**From:** Charlie Craddock - Elite Nugen [REDACTED]  
**Sent:** 26 November 2021 14:12  
**To:** Iqraa Malik  
**Subject:** RE: Planning submission -PP-10337757  
**Attachments:** We sent you safe versions of your files; 1701\_005-Existing First Floor Plan-R.pdf; 1701\_202-Proposed First Floor Plan-R.pdf

Confirming Aggregated Description : "Erection of single storey side extension."

White Lodge  
Rectory Lane

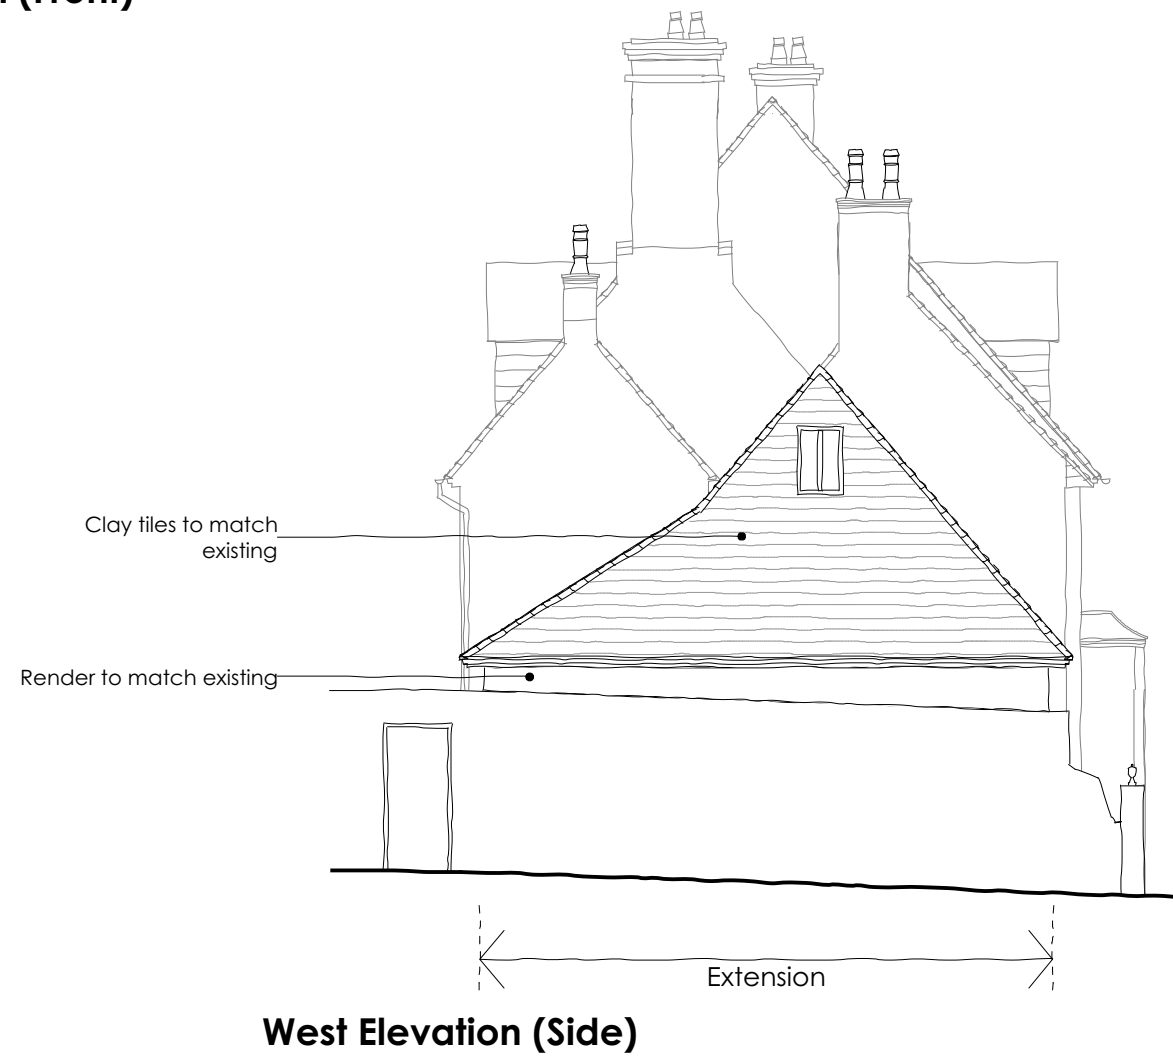
As you have answered no to both questions 4, this means questions 5-7 can be skipped. Please amend. Along with this, the windows are inconsistent between the existing/proposed first floor plans and the existing/proposed rear elevations. Please review and amend.

Plans: The windows are inconsistent between the existing/proposed first floor plans and the existing/proposed rear elevations. Please amend.

Plans: The windows are inconsistent between the existing/proposed first floor plans and the existing/proposed rear elevations. Please amend.
